M3 Junction 9 Improvement

Scheme Number: TR010055

7.12.7 Statement of Common Ground with Cycle Winchester

31 July 2023

DRAWING TITLE  
FIGURE 2.5 - THE SCHEME: TEMPORARY TRAFFIC DIVERSION ROUTES  
APFP REGULATIONS 5(2)(a)  
SHEET 4 OF 12  
DOCUMENT REFERENCE 6.2

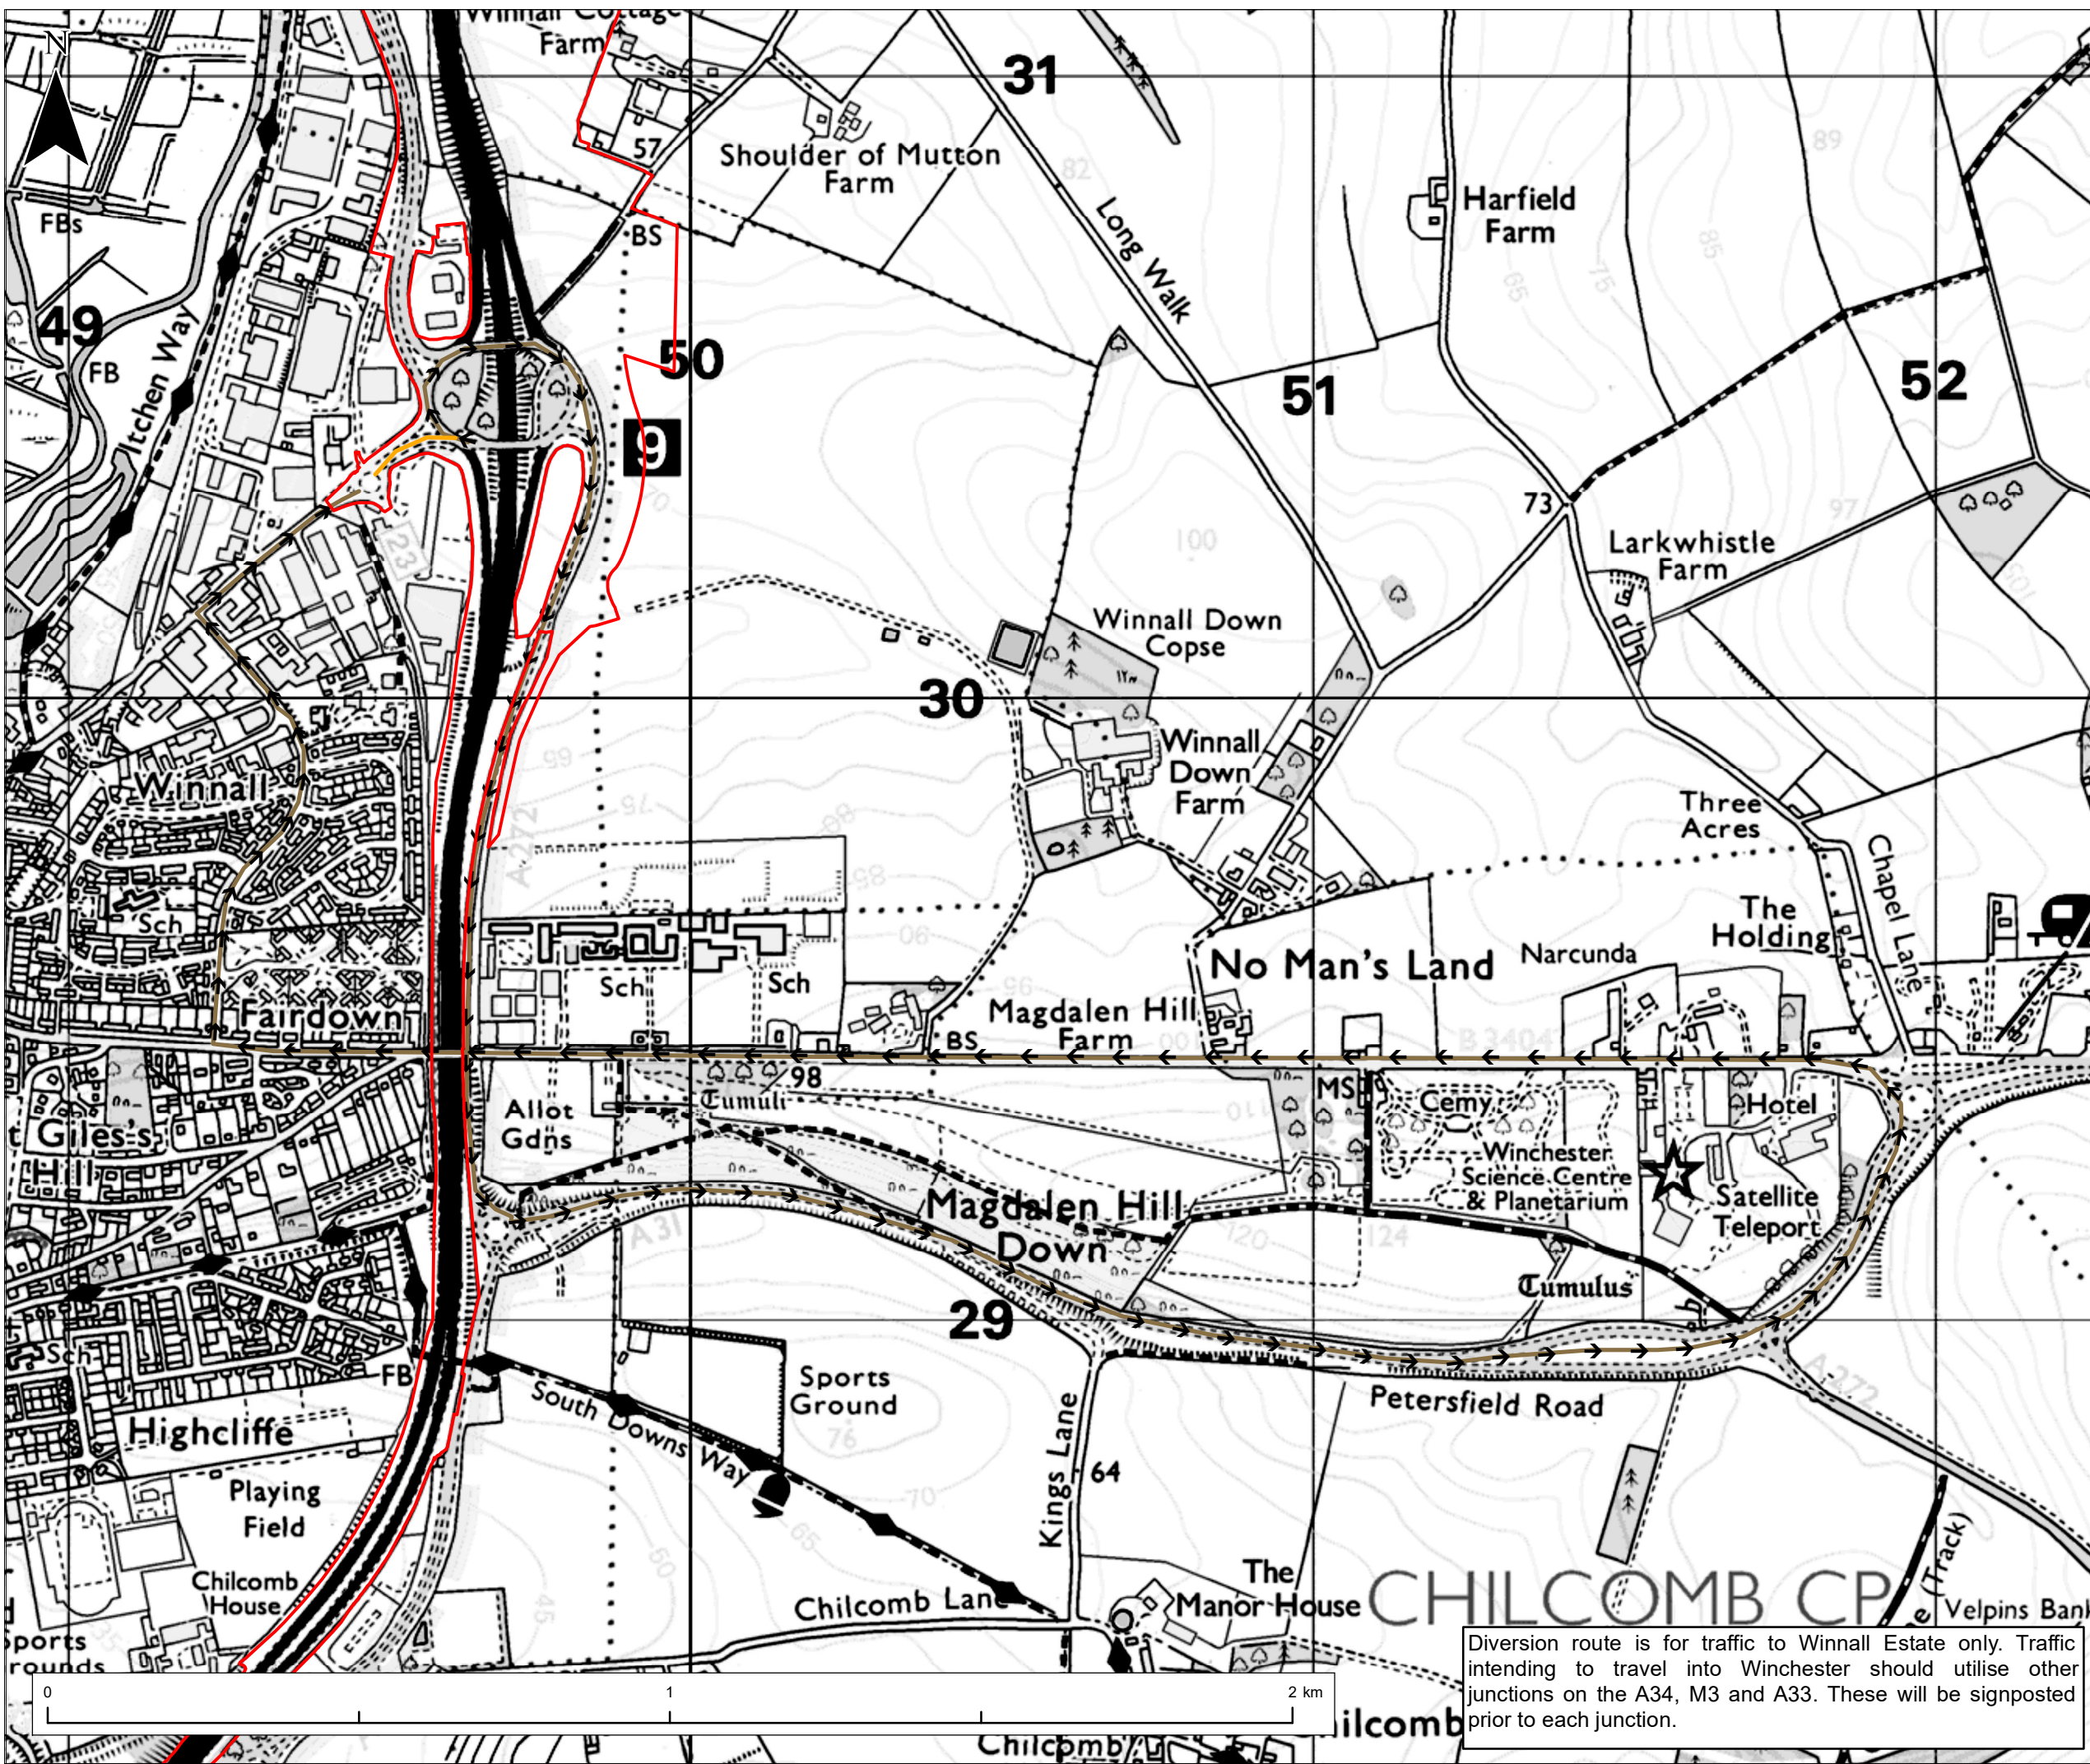
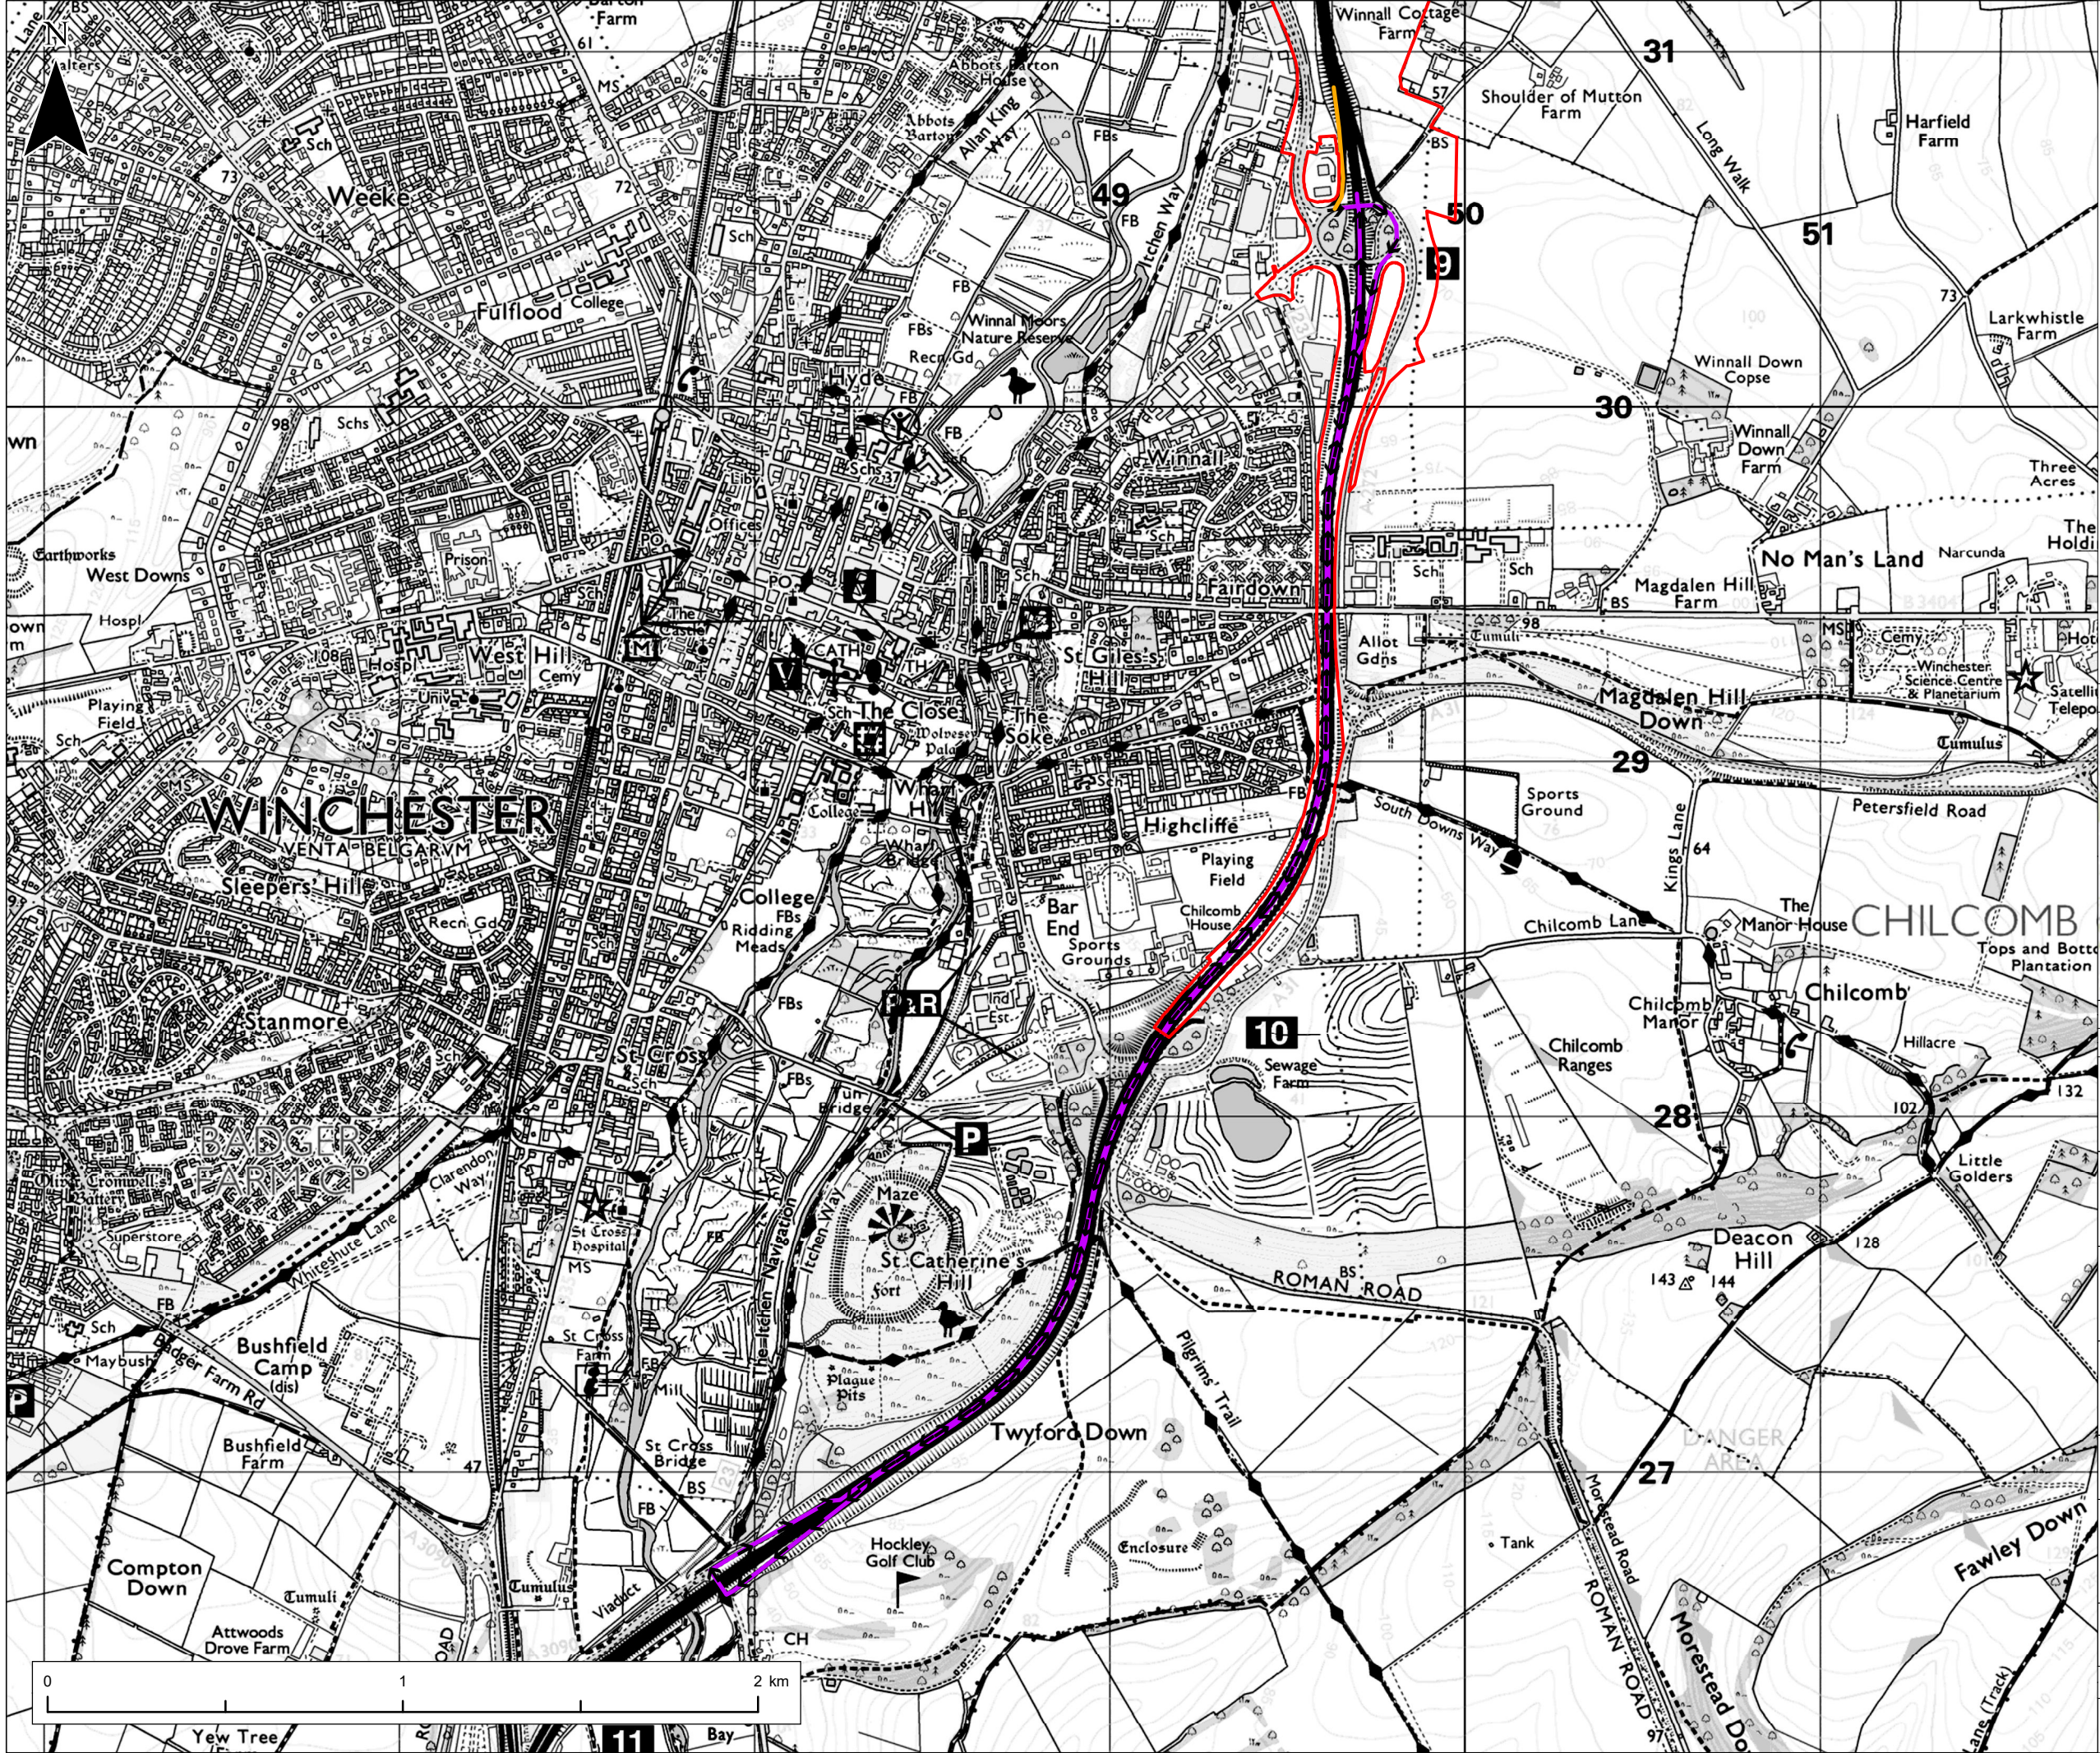
5.2	Diversion routes Impact of traffic diversion on cyclists	Outline Traffic Management Plan (7.8, Rev 1), Figure 2.5 of Chapter 2 (The Scheme and its Surroundings – Figures (Part 3 of 4)) of the ES (6.2, APP-063)	<p>Cycle Winchester has the impression that the project team has not yet considered the impact that traffic diversions during construction will have on cyclists. Examples of areas where the diverted traffic might have an impact on cycling include many of the major routes in and out of Winchester, as a Junction 9 closure or complete M3 closure would force more traffic onto these roads. Some examples:</p> <ul style="list-style-type: none"> ▪ B3047 Worthy Road/Martyr Worthy Road ▪ B3335 St Cross Rd and Twyford Road ▪ B3420 Andover Road ▪ B3330 Bar End Road ▪ Minor roads, especially in the upper Itchen valley east of the junction <p>Again, we would like to see a clear consultation process that will ensure that consultation happens, that the effects on non-motorised road users are accounted for, and appropriate measures are taken.</p>	<p>Diversion routes via the B3047, the B3420 Andover Road and road east of the junction (A31) will be implemented at various stages of the Scheme. The works are planned to be undertaken during overnight off-peak closures (when there is less traffic on the network) and several extended weekend closures.</p> <p>The B3335 St Cross and Twyford Road and B3330 Bar End Road have been referenced as secondary diversion routes and should only be used by non-motorway traffic, or for those accessing the residential area at Bar-End.</p> <p>There are mitigation measures for rat-running and this will be monitored throughout construction of the Scheme.</p>	Agreed	6 July 2023
